Our Case Number: ABP-317121-23

Re: BusConnects Swords to City Centre Bus Corridor Scheme
Swords to Dublin City Centre

Observation for the BusConnects Swords to City Centre Corridor - Case Number 317121

Drawing File Name: BCIDB-JAC-TSM_GA-0002_XX_00-DR-CR-0035	Sheet Number: 35 of 37	Status: A	Rev: M01
---	------------------------	-----------	----------

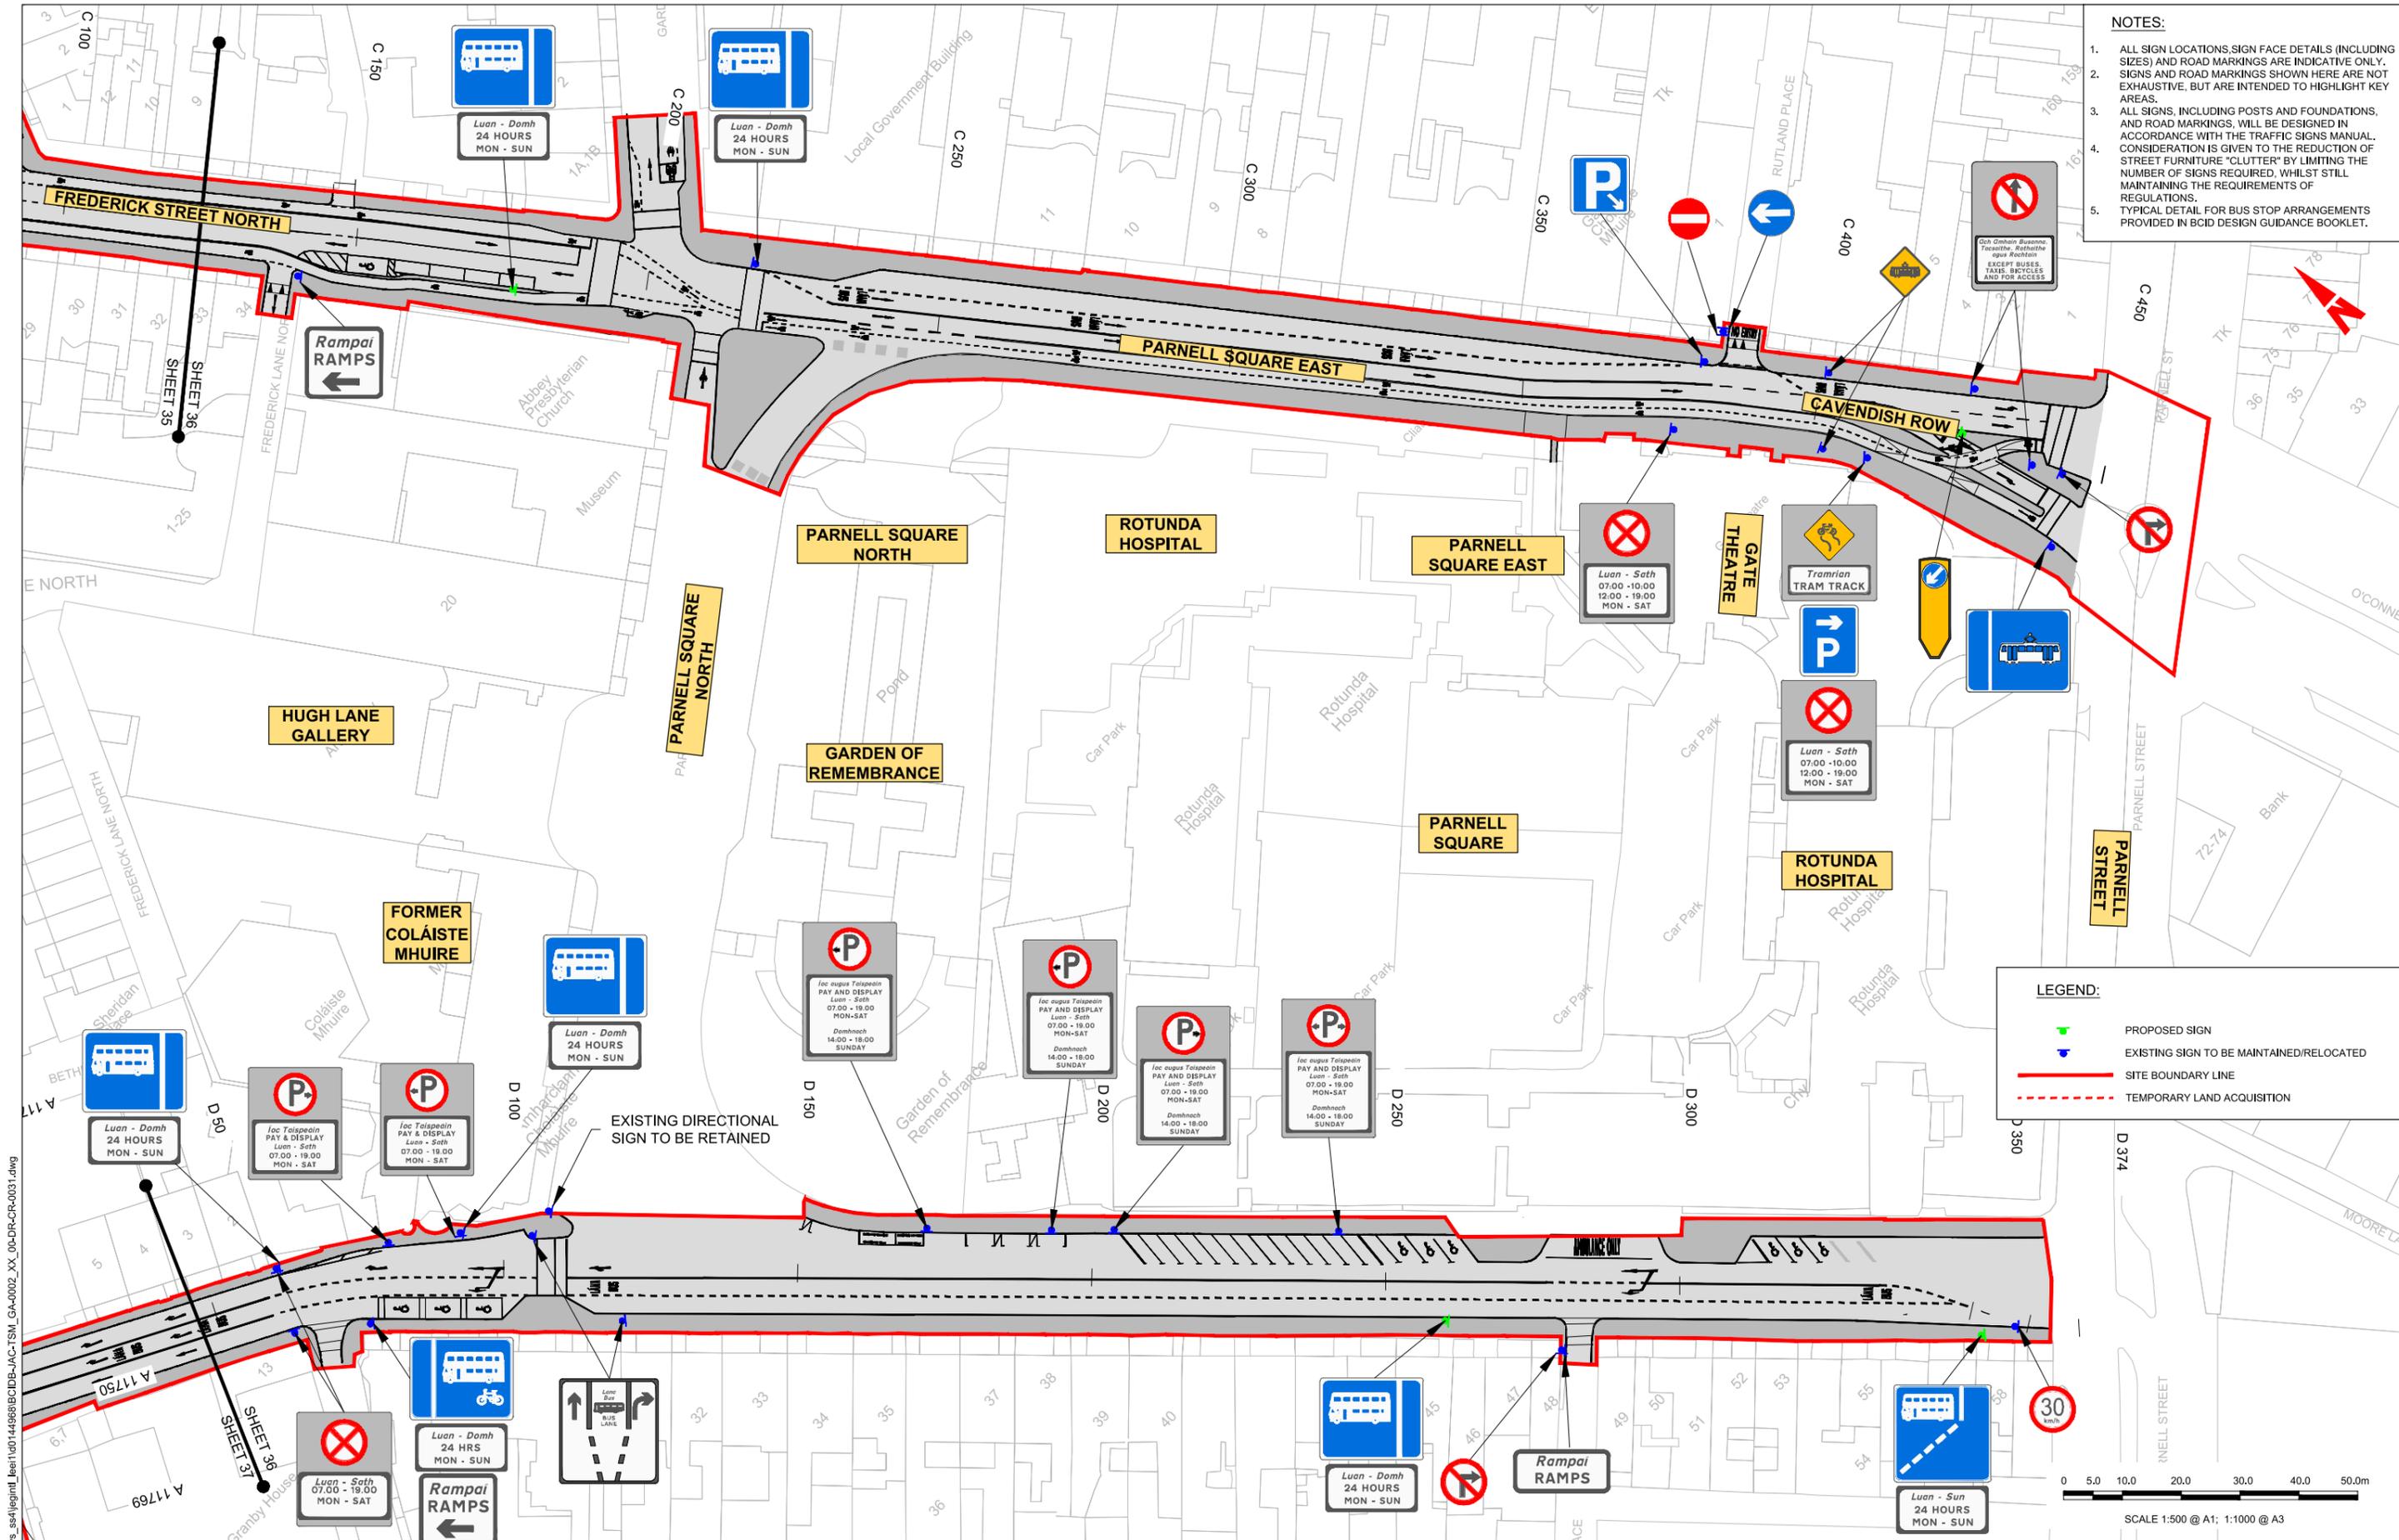
- *Sheet No. 34, Ch A11150* that shows a bus stop will be relocated from a location where no bus stop currently exists.
- *Sheet No. 35, Ch 11450-11500* that incorrectly shows an exception to a right turn ban for motorcycles, cycles and public service vehicles up a one way street (Blessington St), while the left turn ban (with exceptions) for North Frederick Street is missing.
- *Sheet No. 35, Ch 11500-11550* that incorrectly shows a pedestrian crossing, where none exists. No proposal of a new pedestrian crossing at this location is anywhere to be found in the proposed plans.
